Our Ref: WA/92/11/

Removal of existing underground fuel tanks, and installation of new underground fuel tanks, repositioning of vent stack and rerouting of associated underground pipework. New forecourt pavings where disturbed.
Shell Fontwell Arundel Road Fontwell

TITLE : GENERAL SITE PLAN as Existing

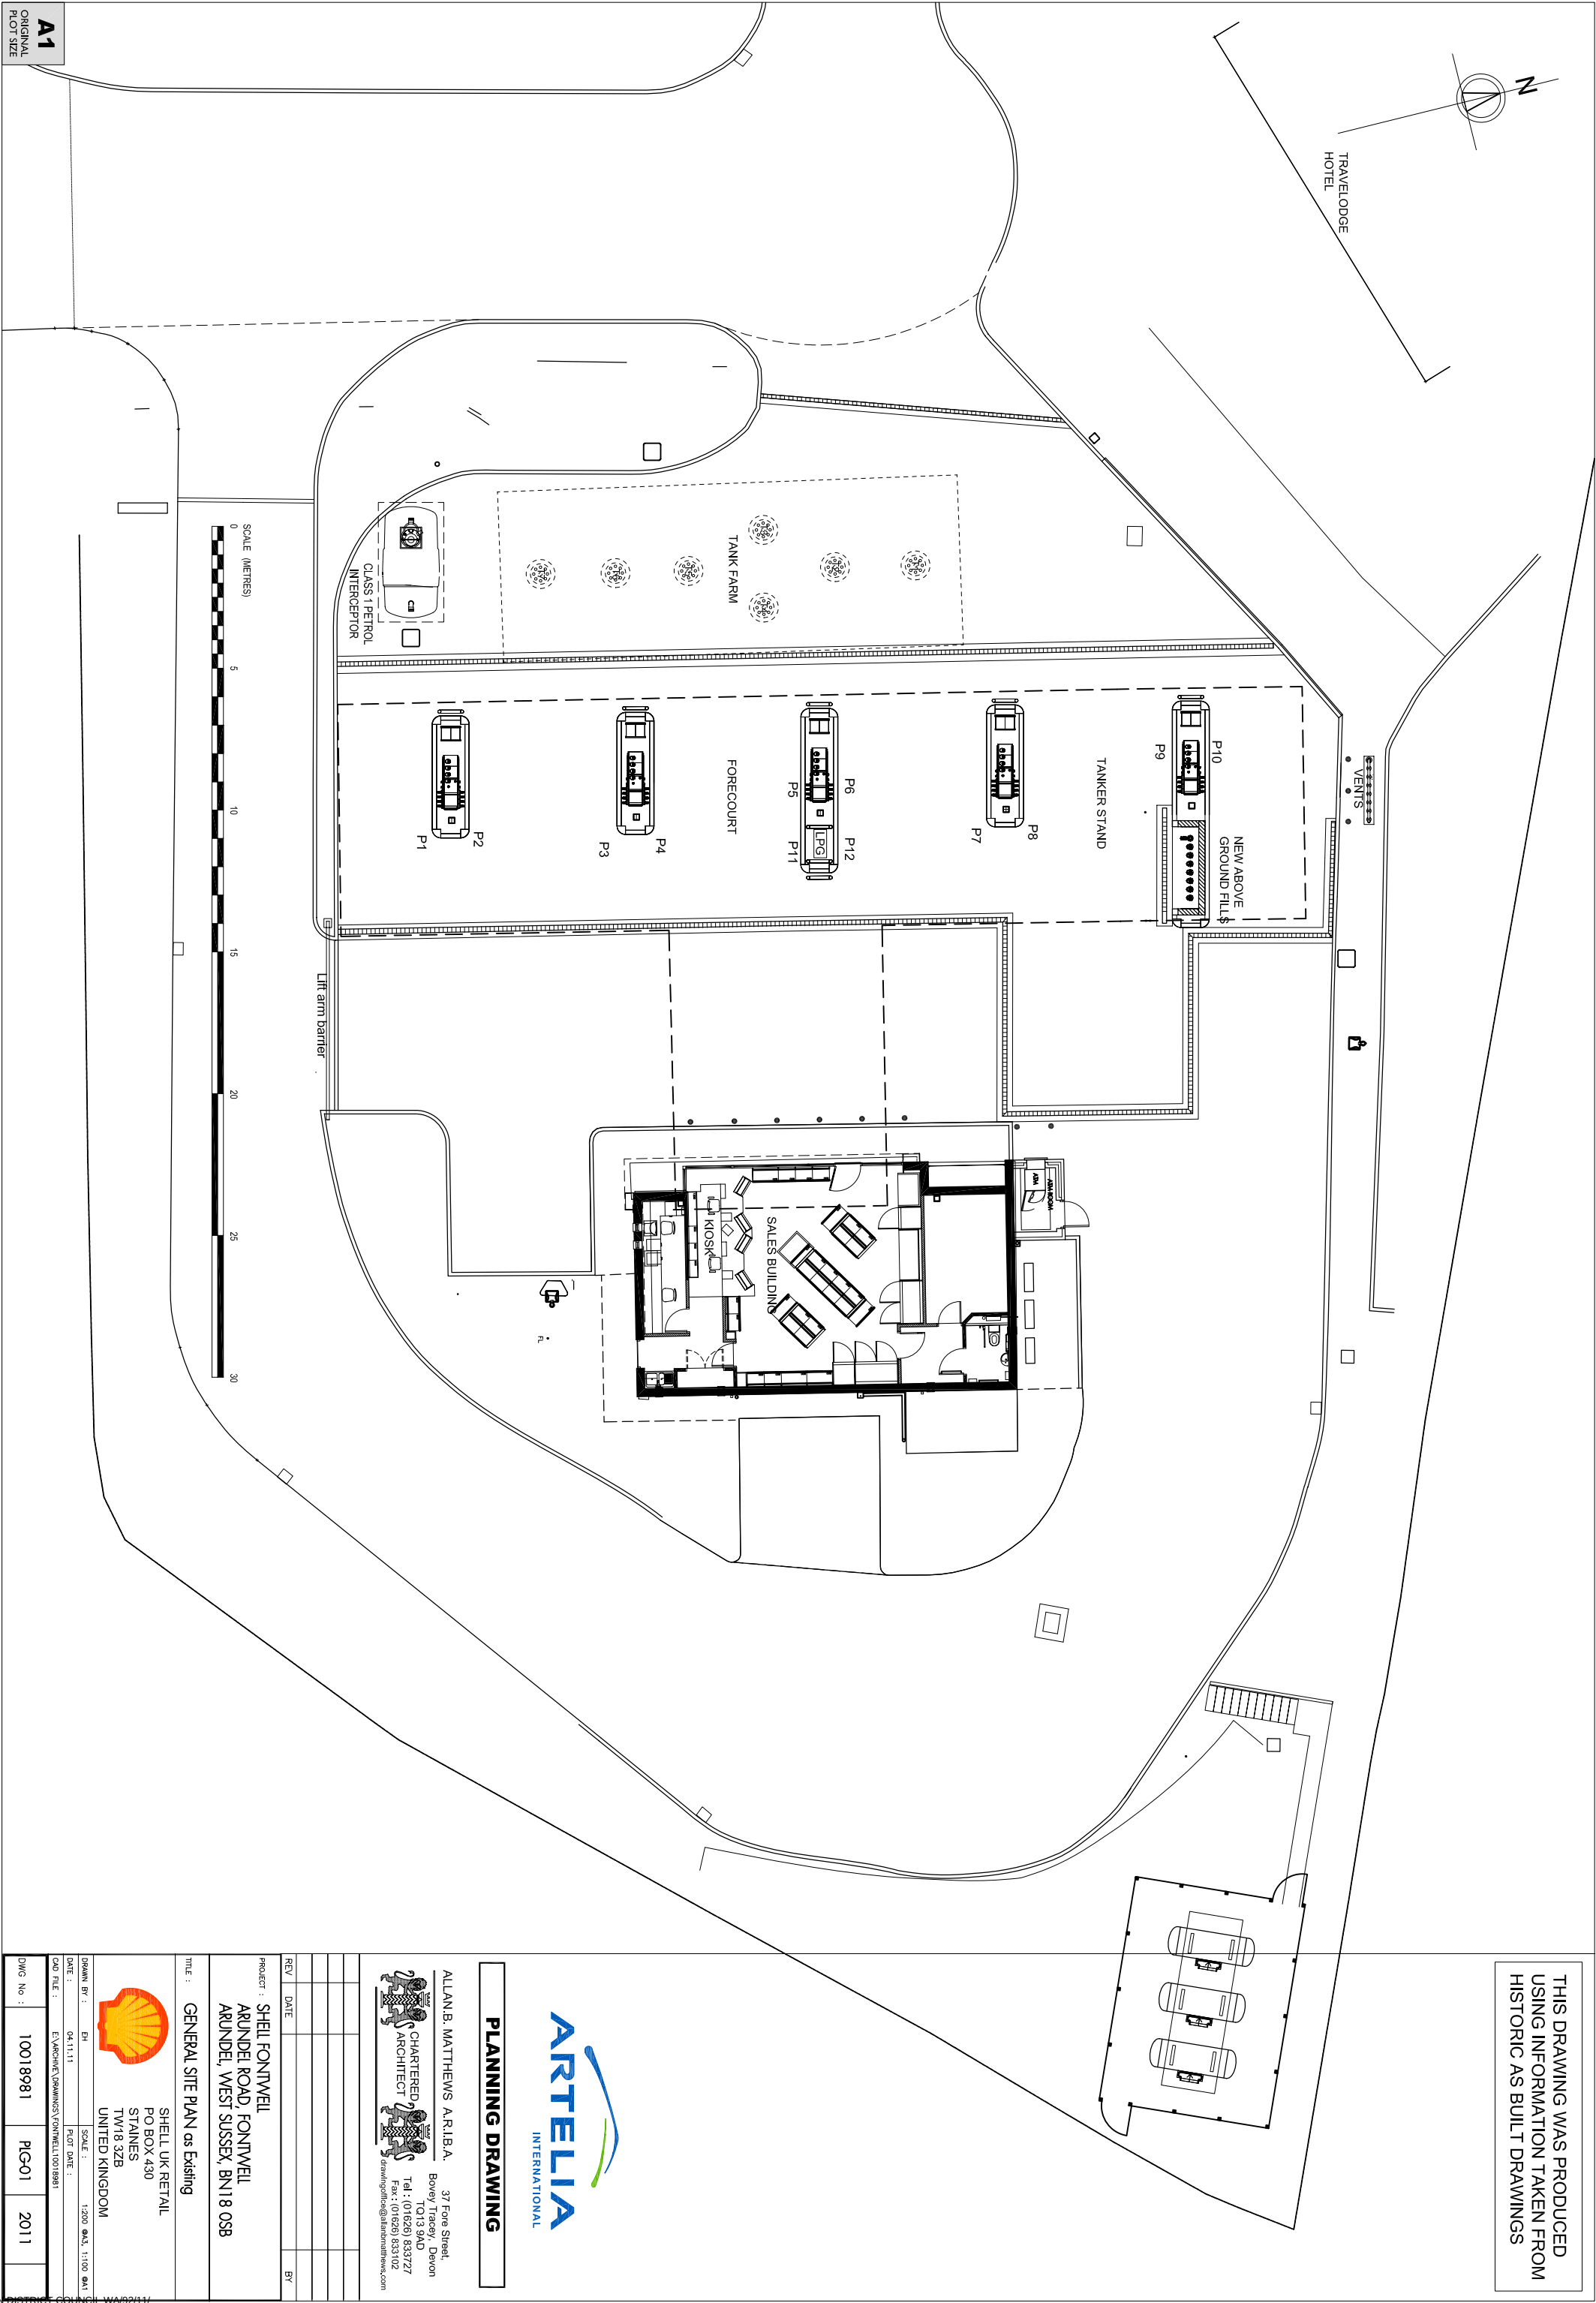
Please submit amended block plans clearly showing the position of the proposed works

11/11 - block plan still incomplete email sent.

WA/92/11

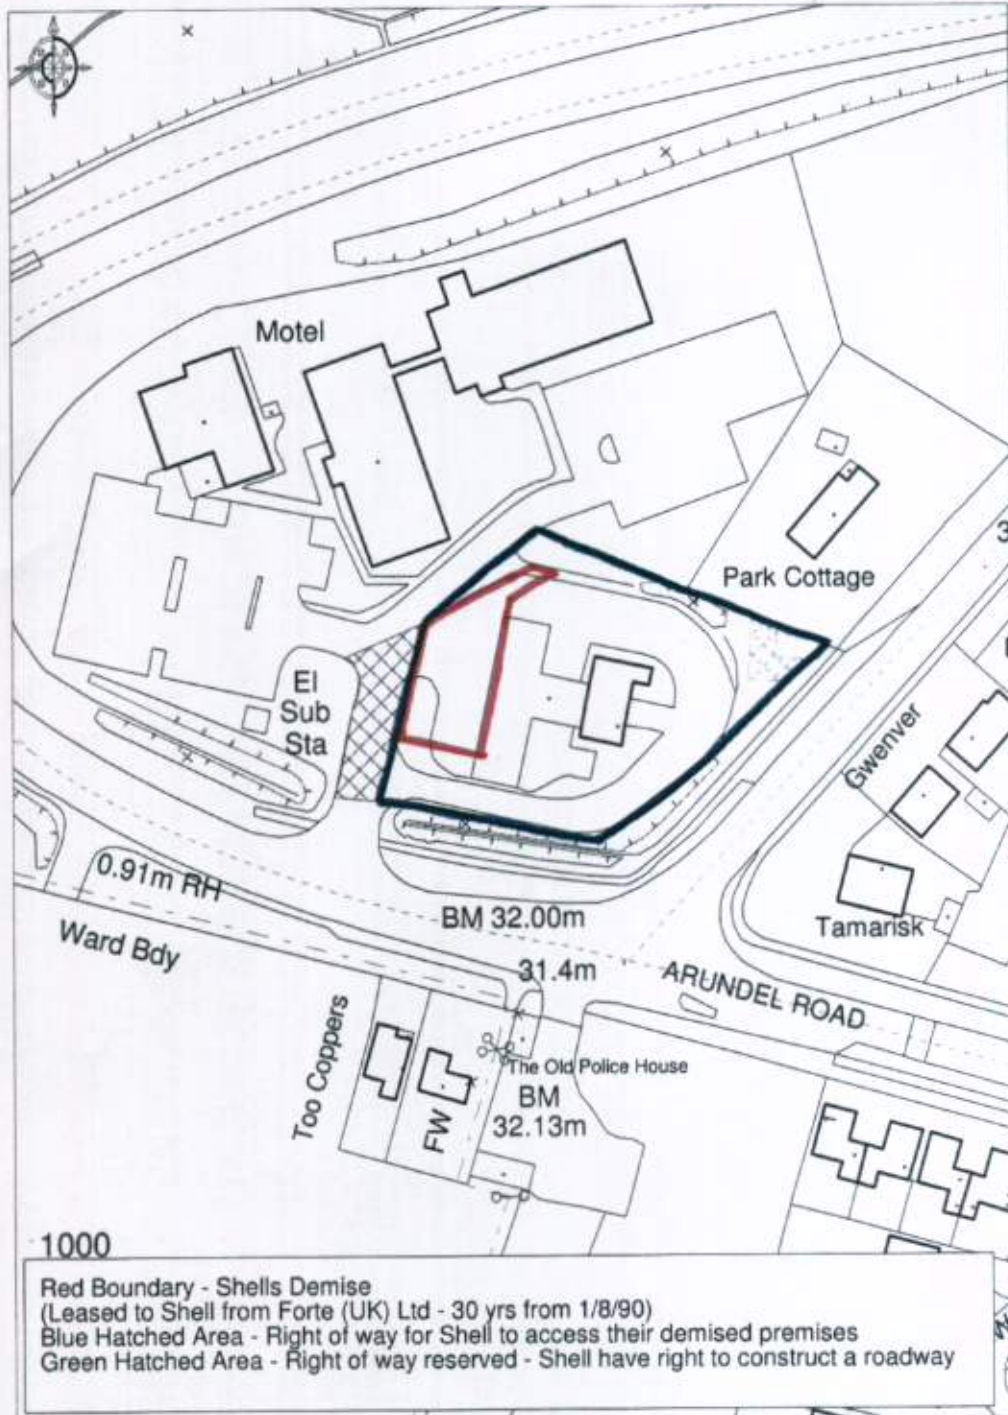
Please submit amended location plans showing any other land owned in blue.
